WELWYN HATFIELD COUNCIL – DEVELOPMENT CONTROL
DELEGATED REPORT

APPLICATION No:	S6/2011/2053/FP
APPLICATION Site:	51 Daisy Drive, Hatfield

The application seeks planning permission for a rear conservatory. In previous correspondence the applicant has stated that the conservatory has been in existence for more than five years.

DESIGNED BY N Cavill	CHECKED BY	APPROVED BY	DATE	DATE 21/11/2011
SCALE 1:50			PROPOSED REAR ELEVATION	
DD51PRE			ISSUE A	SHEET 1/1

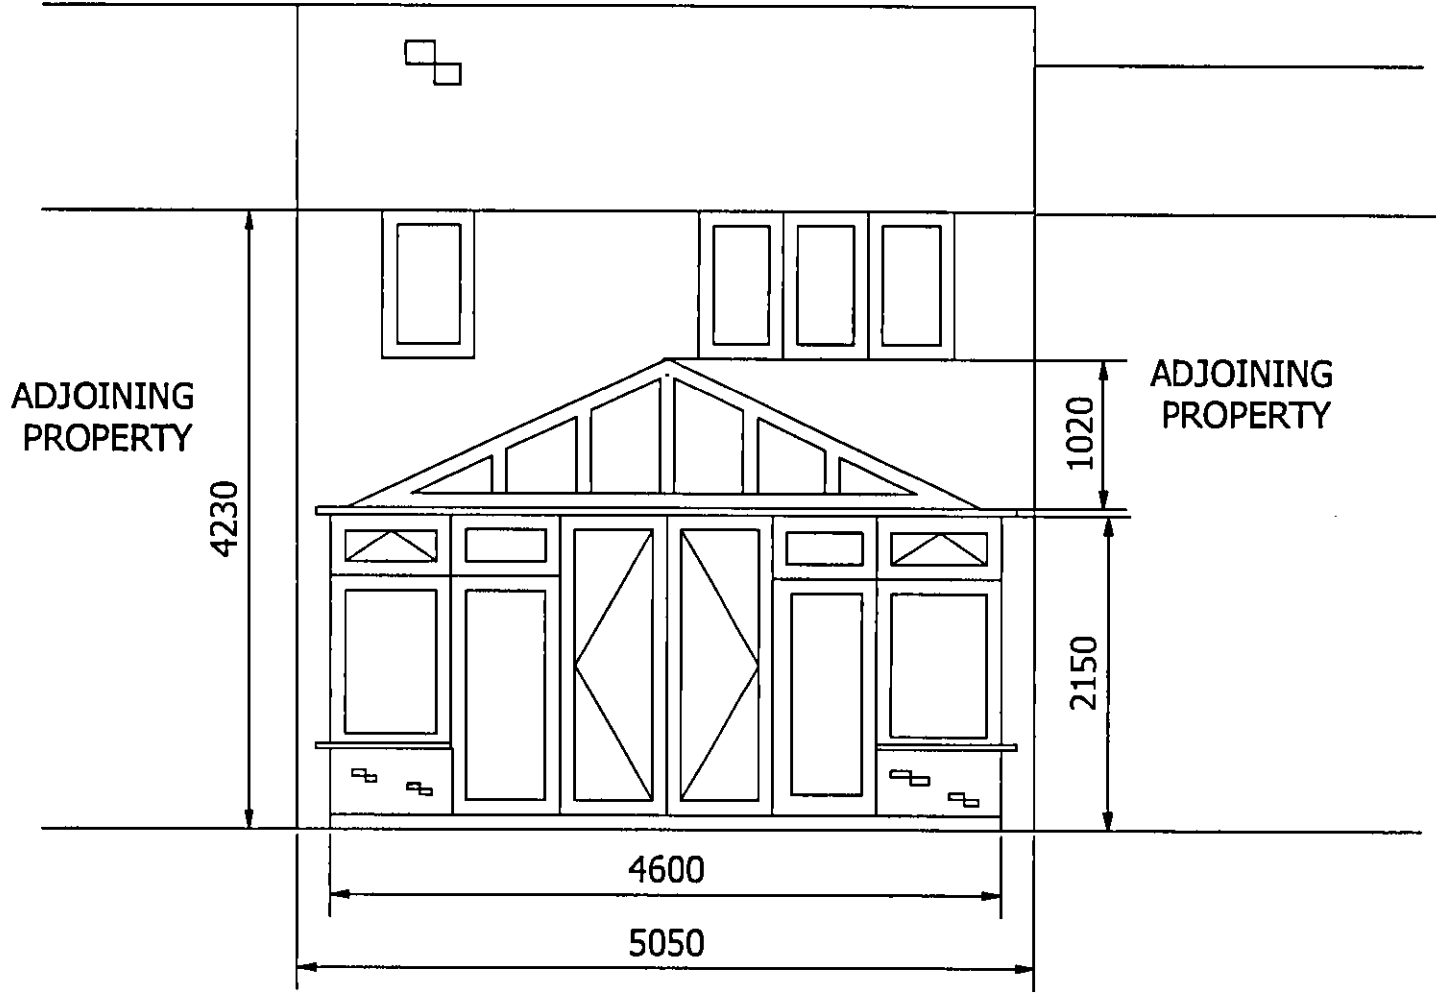
The development is single storey and sited to the rear of the property. The brickwork matches that of the main dwellinghouse and the conservatory is considered subordinate to the main dwellinghouse. The conservatory has an appropriate design and does not have an adverse impact upon the character and appearance of the locality. The garden space is practical, useable and is considered to be acceptable for a dwelling of this size.

DESIGNED BY N Cavill	CHECKED BY	APPROVED BY	DATE	DATE 21/11/2011
SCALE 1:50			PROPOSED SIDE ELEVATIONS	
DD51PSE			ISSUE A	SHEET 1/1

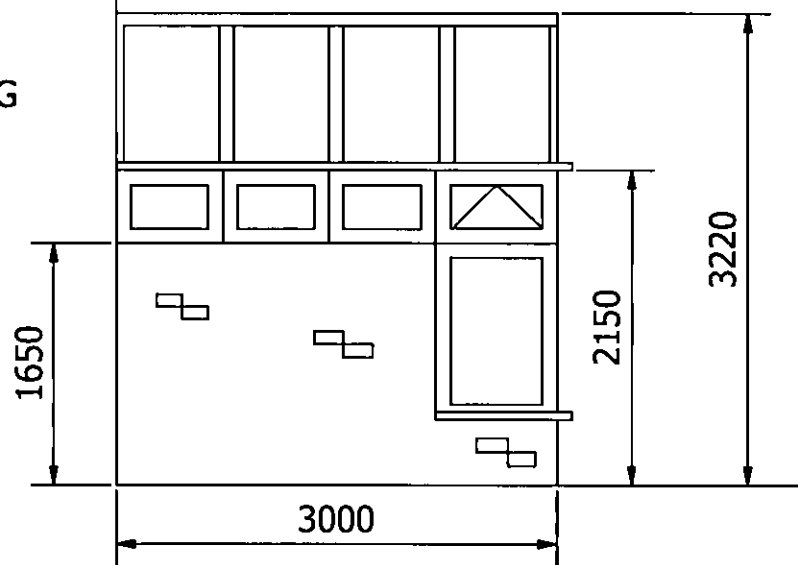
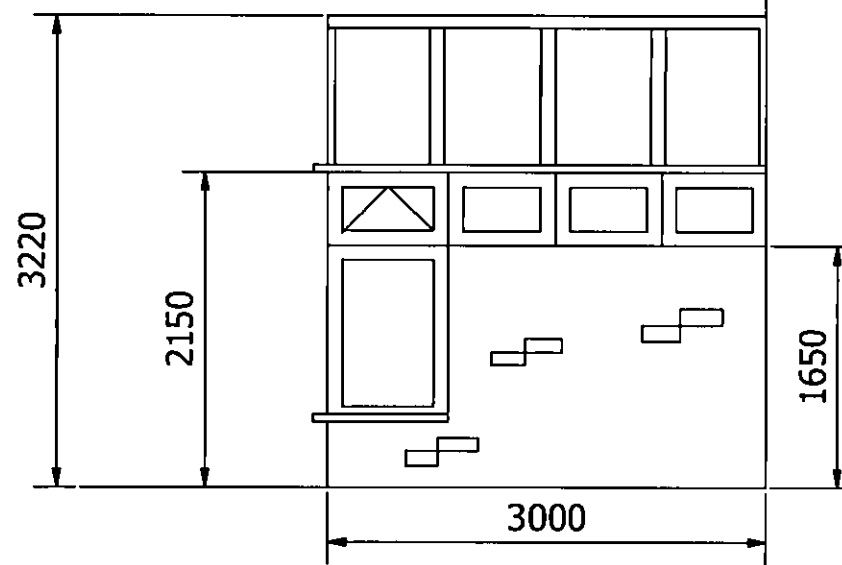
The existing conservatory is east facing and therefore the dwelling most impacted upon in terms of loss of sunlight/daylight is neighbouring dwelling to the north, No.49 Daisy Drive. The eaves height of the conservatory measures 2.15m and an approximately 1.7m high fence forms the boundary with No.49. Whilst the proximity of the conservatory to the boundary with No. 49 would result in some loss of sunlight/daylight to the ground floor window of No.49, it is not considered to be a level to warrant refusal taking account of the eaves height and the pitched roof design of the conservatory.
